Recommendation Report for Planning Permission for Works or Extension to a Dwelling

REF NO: FP/74/19/HH

LOCATION: 8 Ferring Gardens
Felpham
PO22 8HW

PROPOSAL: Single storey extension to existing conservatory and replacement of existing conservatory roof.

Emma Pinder Architects Ltd		Client's Name	Job Title	Drawing Title	Scale	Drawn	Checked	Date	Status
2 Oak Tree Lane, Chichester West Sussex, PO20 3GU T 07809 621606 E epinder@epinderarchitects.co.uk		Mr and Mrs Blythman	8 Ferring Gardens, Felpham	Proposed Plans	1:50@A1	EP	GP	27.03.19	FOR APPROVAL

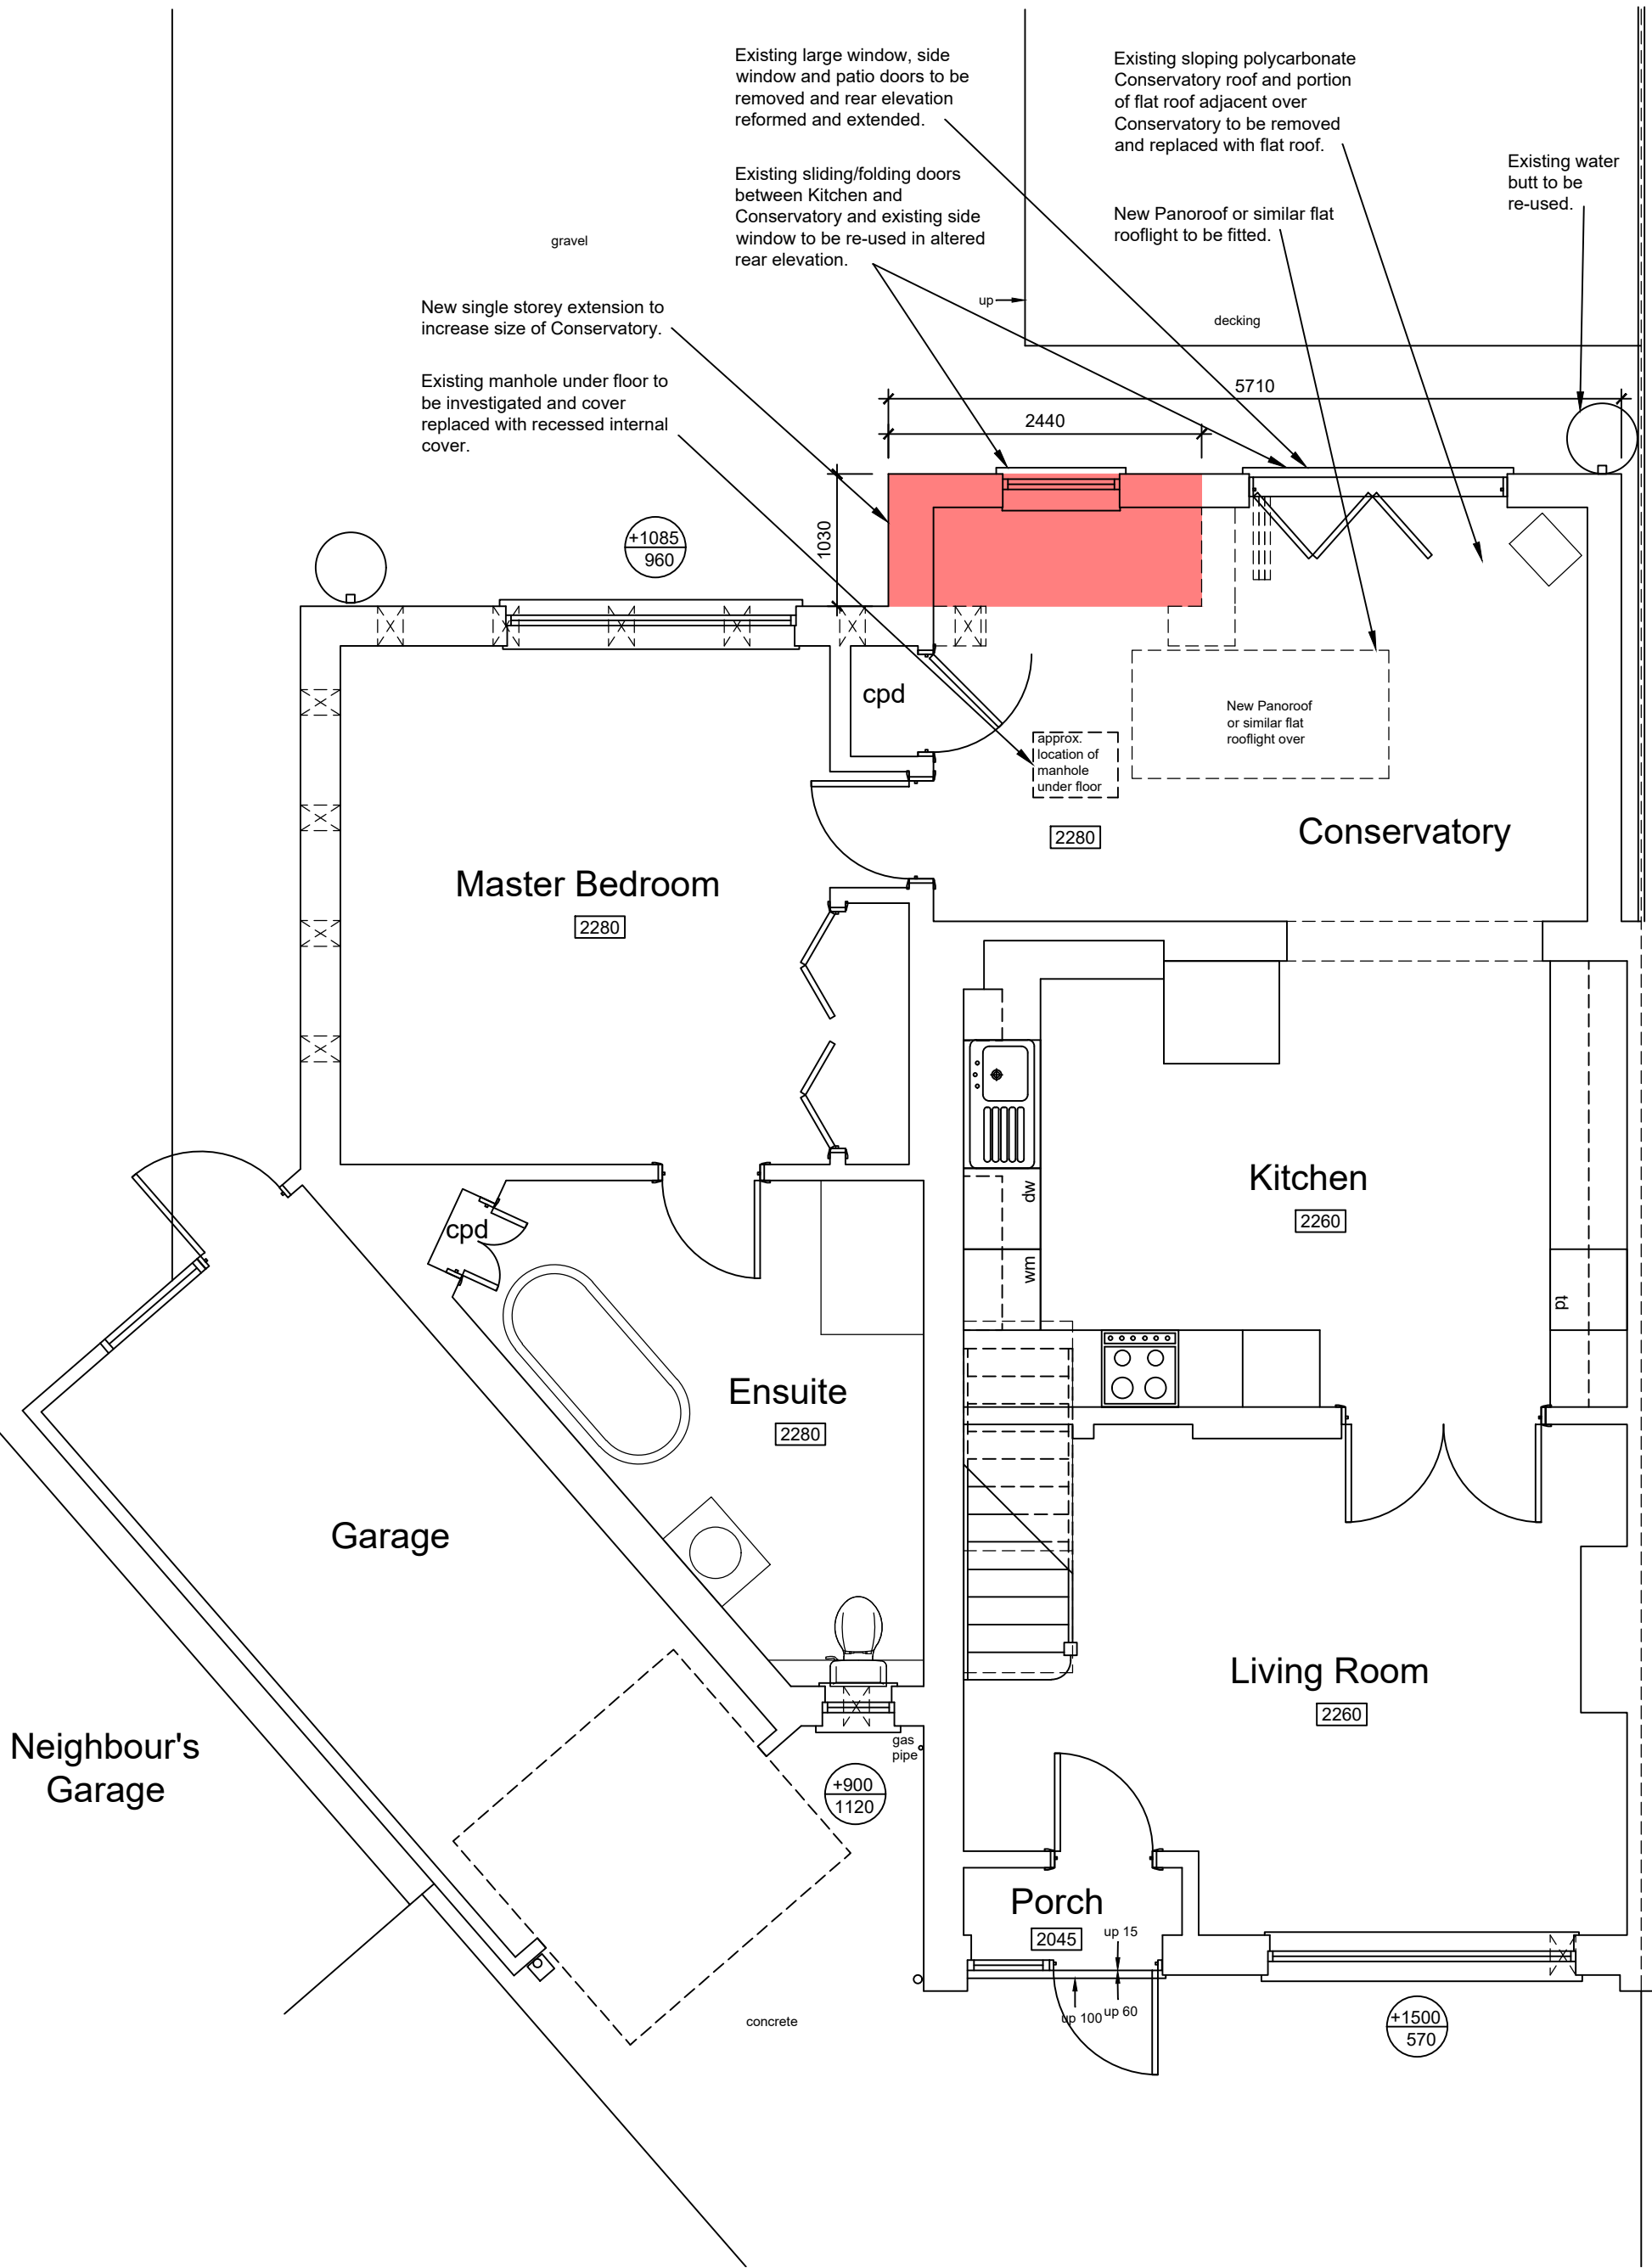
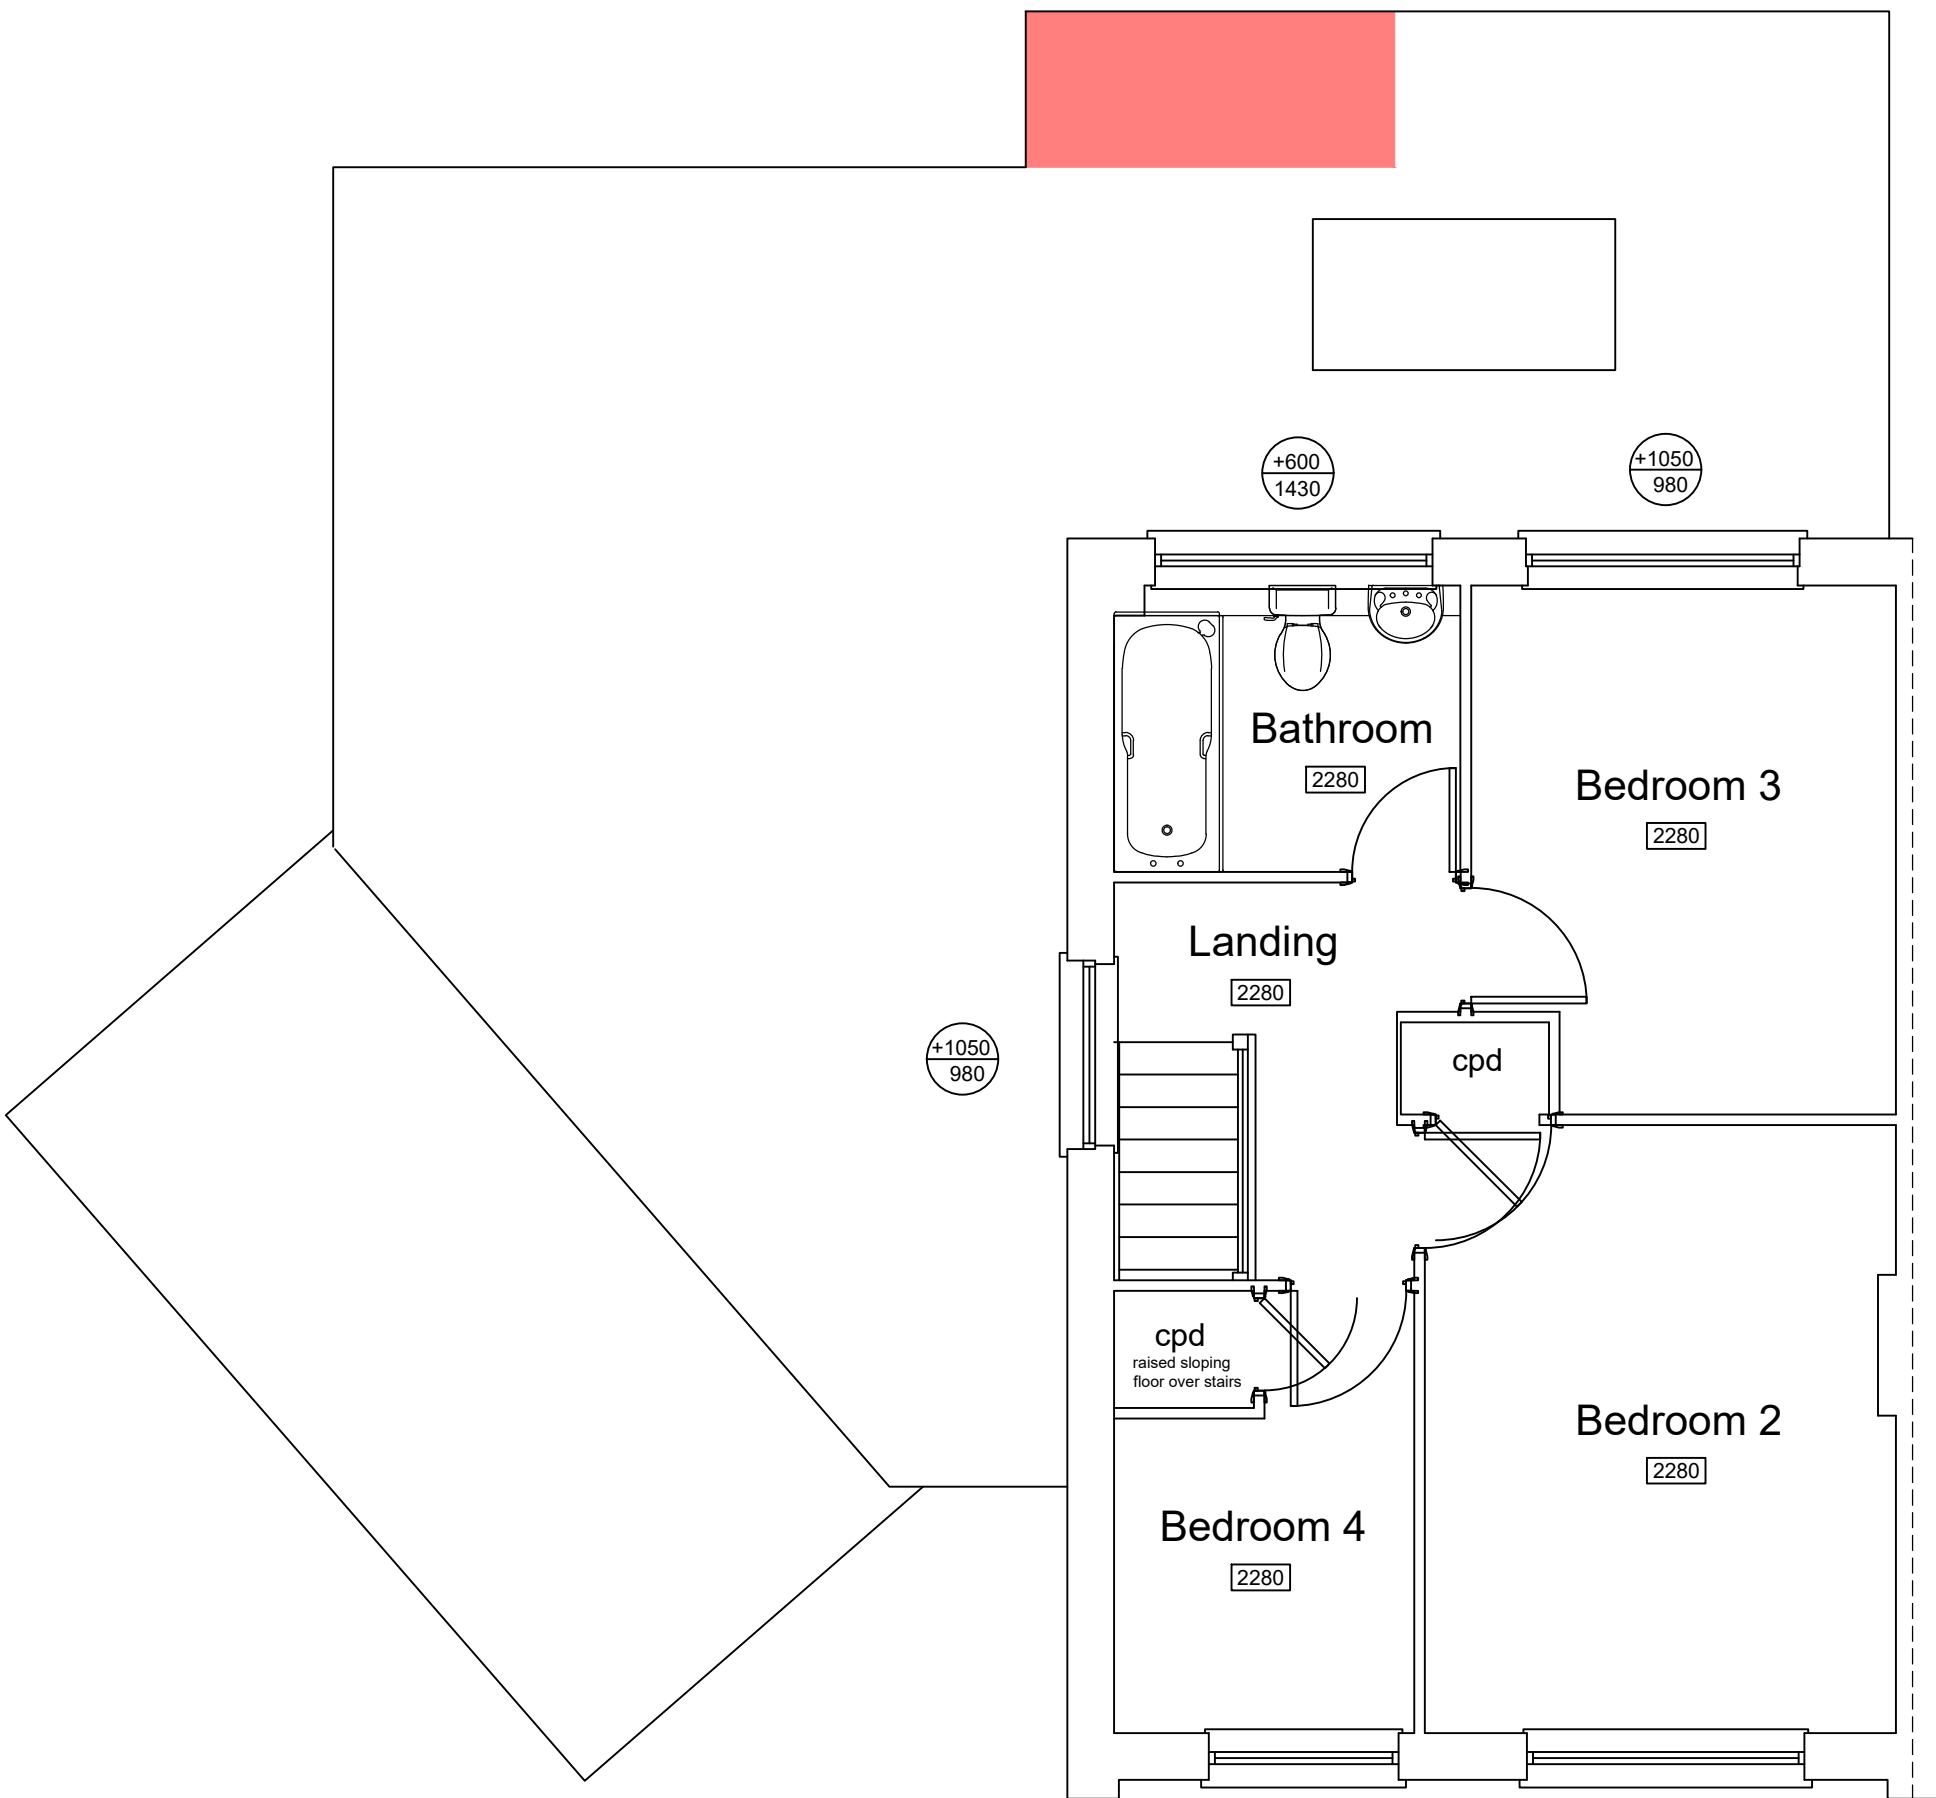
The extension is sited to the rear of the property and as a result is not visible from the street scene or wider area. The extension appears subservient to the host dwelling and is modest in size increasing part of the existing extension by 1m in depth and 2.4m in width. Materials will match that of the existing dwelling.

There will be doors to the rear which replace existing and with the development at single storey it is not considered to give rise to any adverse overlooking upon neighbouring amenity with the depth of the extension only increasing by 1m.
